# THE RESERVE AT CORRAL BLUFFS FILING NO. 4

A REPLAT OF TRACT A, THE RESERVE OF CORRAL BLUFFS FILING NO. 3  
 A PORTION OF THE EAST HALF OF SECTION 31 AND WEST HALF OF SECTION 32  
 TOWNSHIP 13 SOUTH, RANGE 64 WEST OF THE 6TH P.M.  
 EL PASO COUNTY, COLORADO

# Final Plat\_V1.pdf Markup Summary

## THE RESERVE AT CORRAL BLUFFS FILING NO. 4

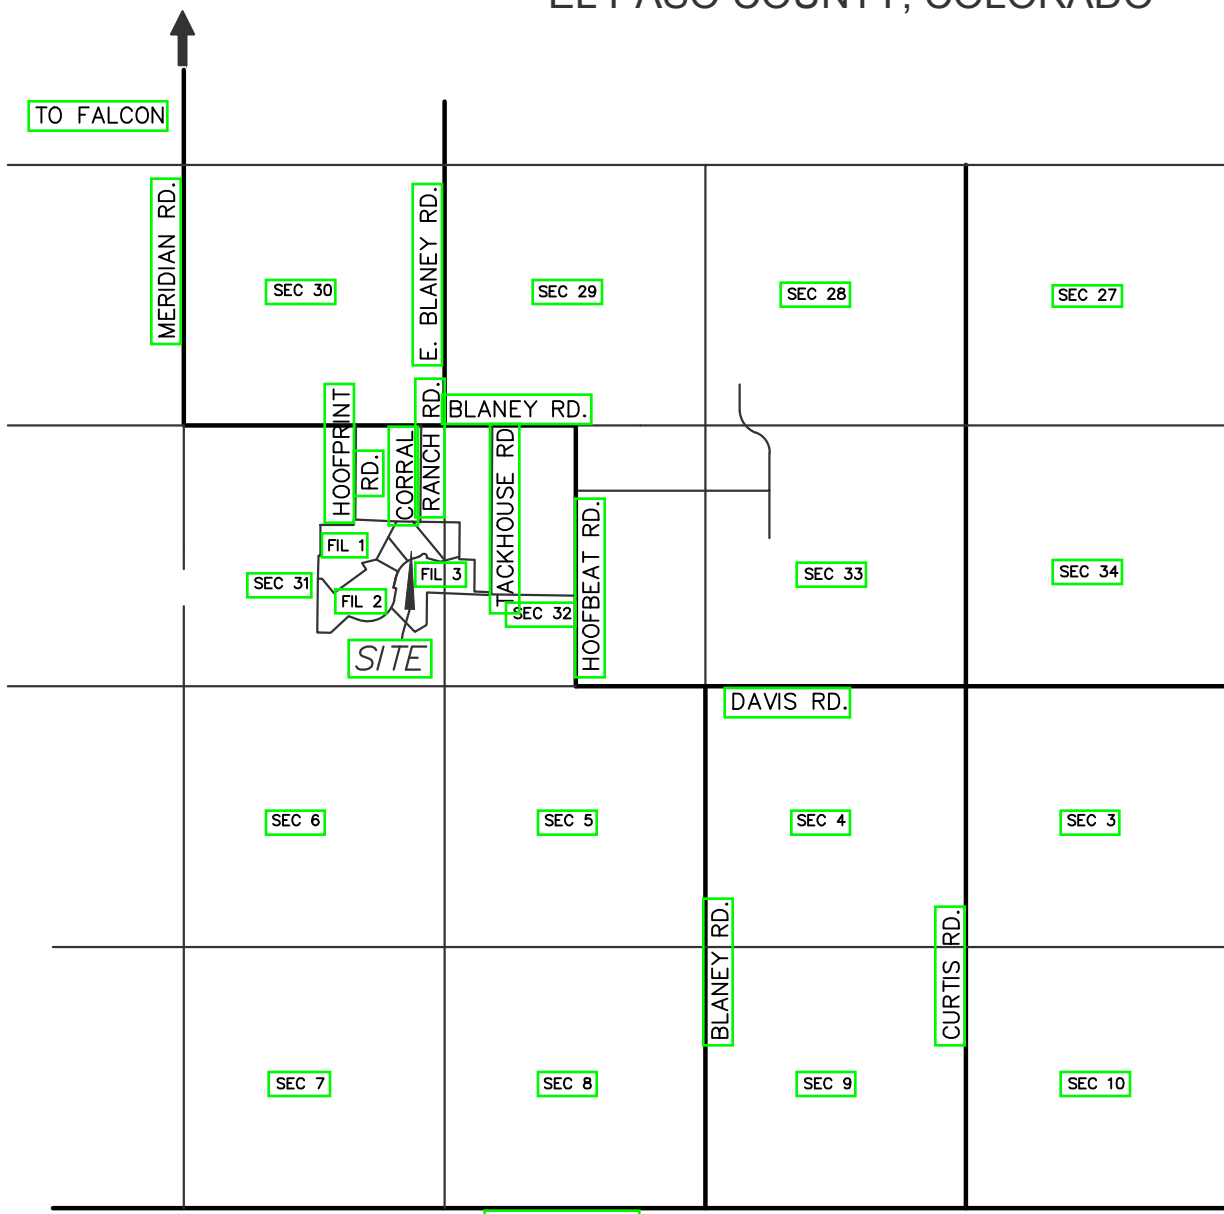
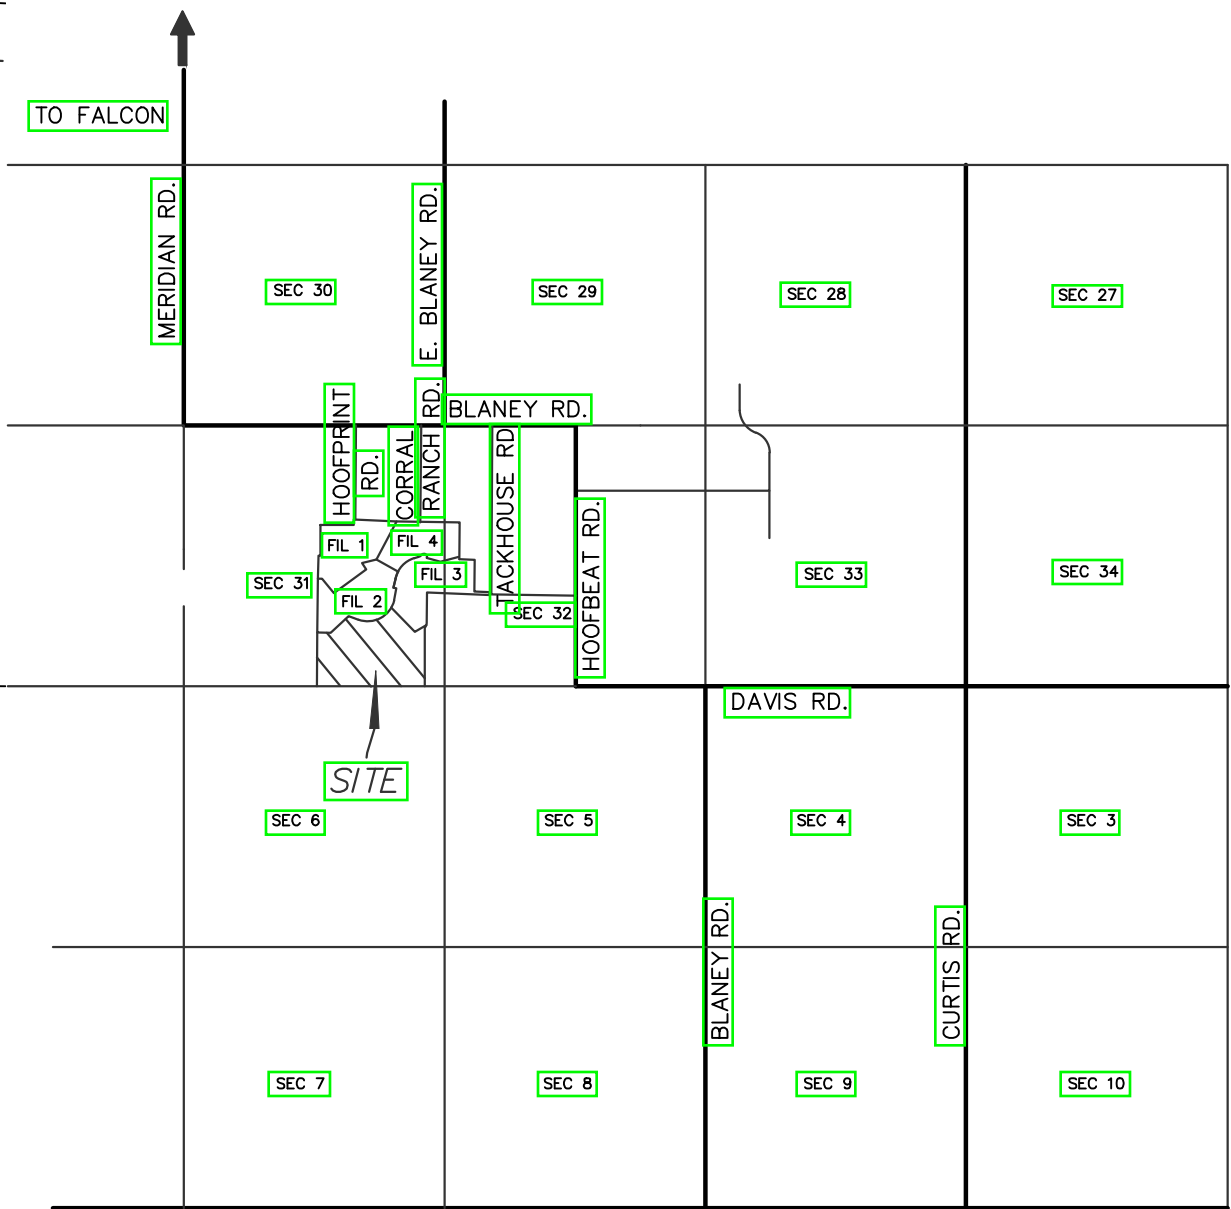
Lot 4 is shown to have issues in Soils and Geology Report but not identified, areas of ponding water should have no build area on plat

Note 1 should be about why you are vacating and replatting, ie. The parcel was platted as a tract in previous filing to not create an illegal parcel, being vacated and replatted for this filing for future development or similar language.

Revise the easement to include public improvements as shown on the road section in the construction documents of Filing 3.

delete the crossed out text.
